Address: The Dell Burnlee Road Holmfirth HD9 2LF

Application number: 2023/93342	
What is the application for?:	Outline application for demolition of existing dwelling and garage and erection
Address of the site or building:	Moss View, Burnlee Road, Holmfirth, HD9 2LE
Postcode:	HD9 2LE

SITE PLAN (1:200)

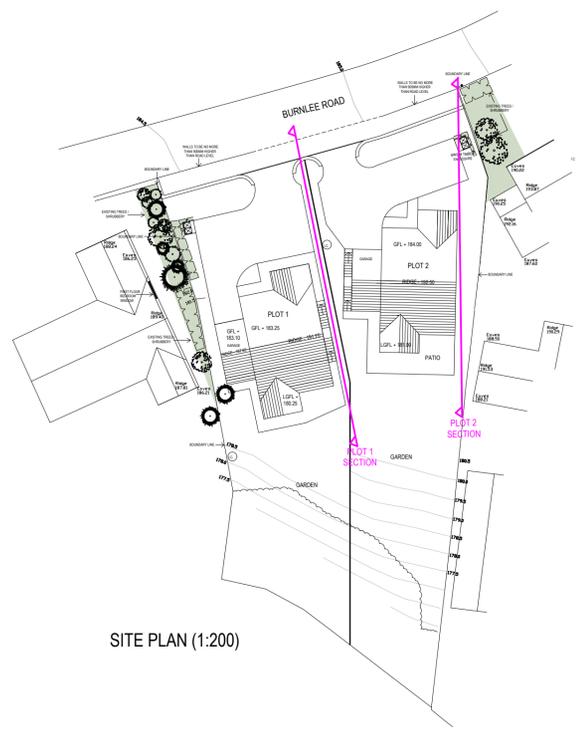
Type of comment: A general comment	
Do you wish your comments to be published on the website anonymously?	No
I live next door at the Dell. On the proposed revised plans, they have marked a bedroom window. There are other bedroom windows and the side and back of the house, that will lose light and potential privacy concerns. My sewage pipes go right under the proposed houses. These can be moved. And the rights of access for maintenance addressed. And there is a surface water drainage pipe along the boundary between the 2 properties.
